**From:** Chantelle Bashford [Redacted]  
**Sent:** 12 November 2025 12:01  
**To:** Planning.Responses <Planning.Responses@arun.gov.uk>  
**Subject:** RE: Planning Consultation on: BR/162/25/PL

**Application No:** BR/162/25/PL  
**Registered:** 10th October 2025  
**Site Address:** 90 Aldwick Road Bognor Regis PO21 2PD  
**Grid Reference:** 492606 98860  
**Description of Works:** Change of use from C1 (9 bed) (Bed and Breakfast) to a 9 bedroom, 9 occupant HMO (Sui Generis) with minor internal alterations. This application is in CIL Zone 4 (Zero Rated) as other development.

Drawing Title
Proposed Floor Plans

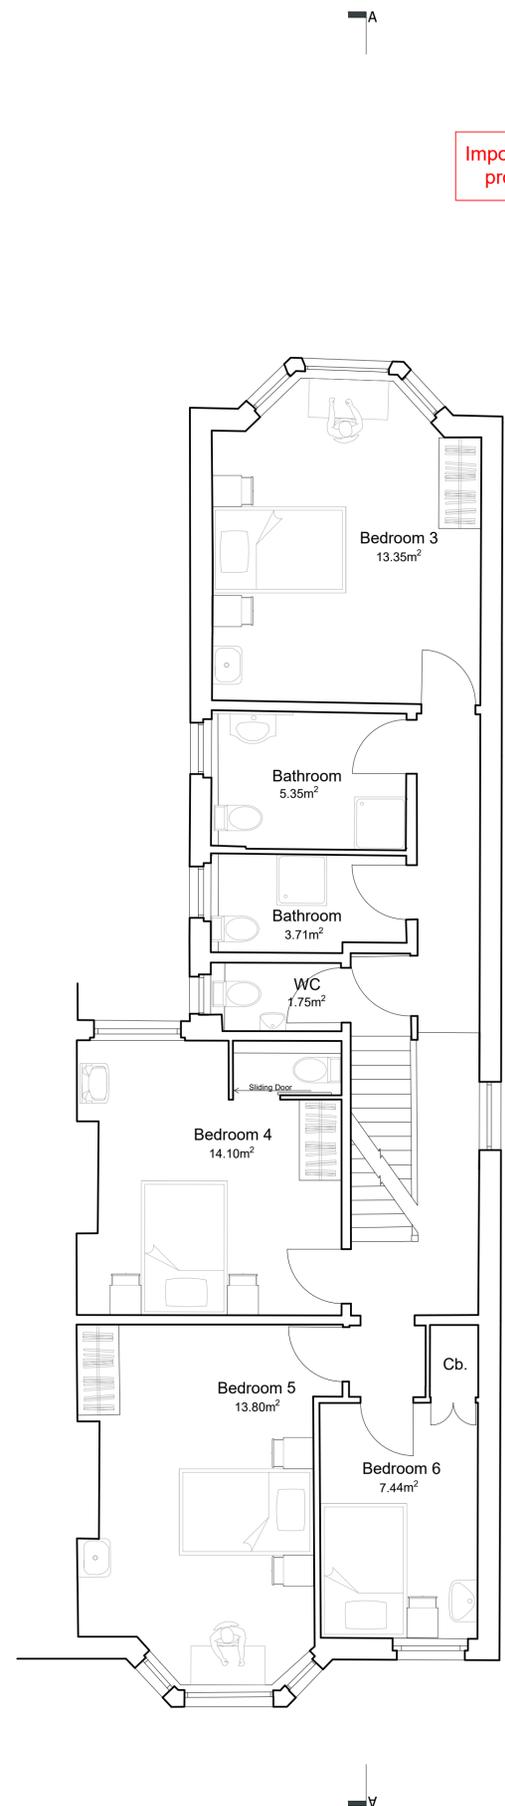
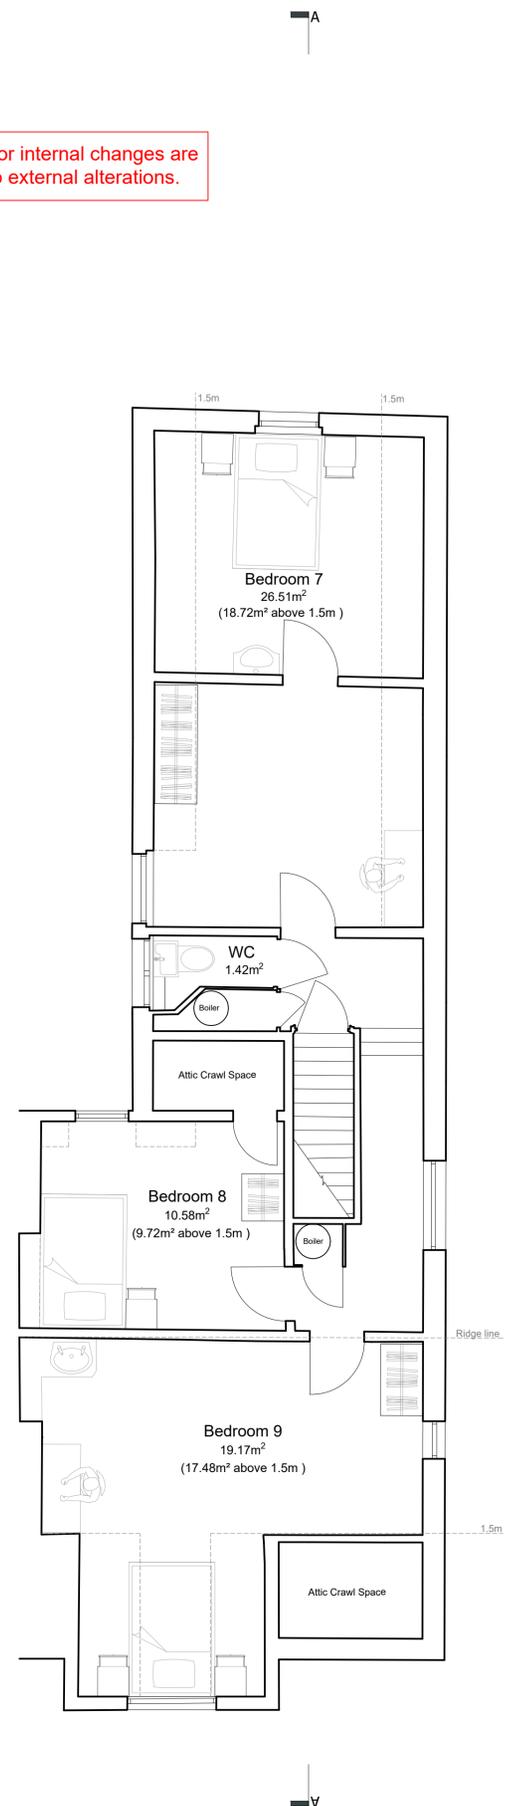
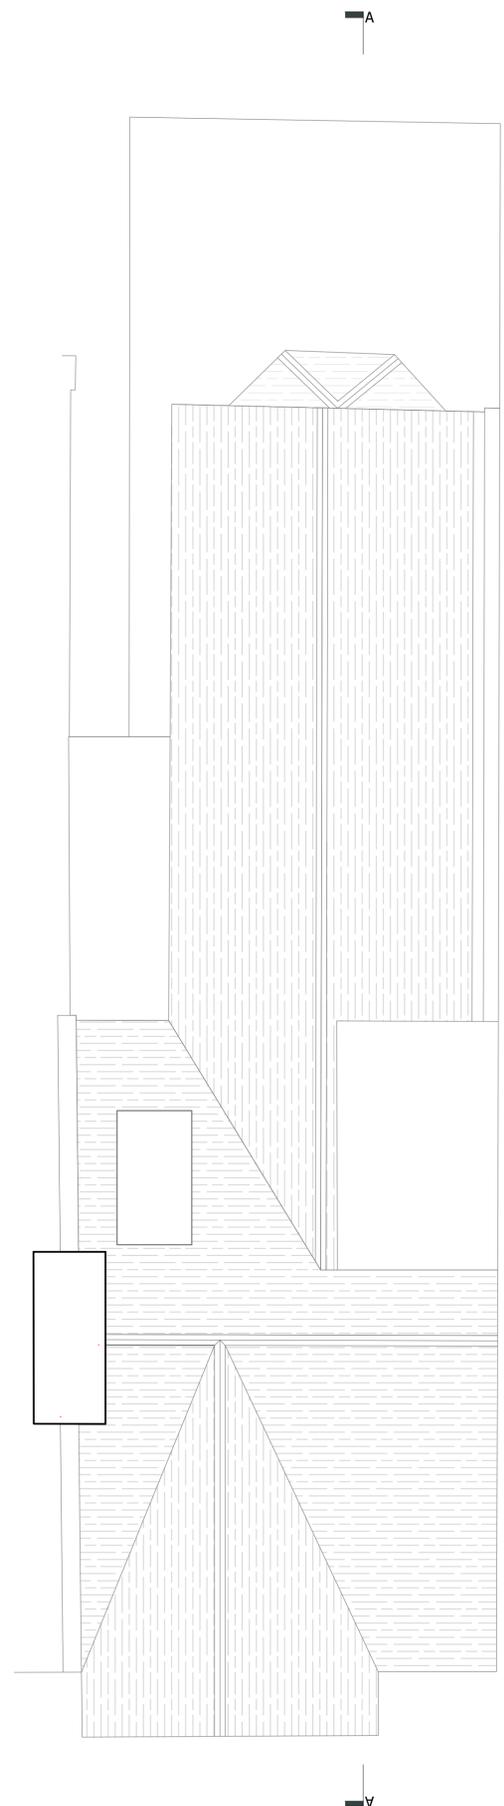
- The proposed ensuite bathrooms within bedrooms 1 & 2 do not appear to be of an appropriate size/layout to provide adequate changing and drying space for the user. From the proposed plans, the ensuite bathrooms appear quite compact, increasing the likelihood that the users would potentially collide with the walls and/or the amenities around them. The Licensing and Management of Houses in Multiple Occupation and Other Houses (Miscellaneous Provisions) (England) Regulations 2006 specifies that all bathrooms must be of an adequate size and layout, which is also echoed within Arun's HMO Standards. In addition, this could be identified as a hazard under the Housing Health and Safety Rating System (HHSRS). It is also likely that, given the limited space available within both bathrooms, certain facilities would potentially be undersized (e.g. the wash hand basins). Therefore, consideration should be given to reconfiguring the ensuite bathrooms

- All bathrooms/ensuites and separate WC compartments must have a suitable wash hand basin installed within them (please refer to Arun's HMO standards with regards to minimum requirements etc). The WC compartment within bedroom 4 and one of the first floor bathrooms appears to be lacking a wash hand basin. N.B. It is acknowledged a wash hand basin is sited within the room of bedroom 4, but a wash hand basin should be sited within the same room/compartment as the toilet to limit the spread of germs/pathogens
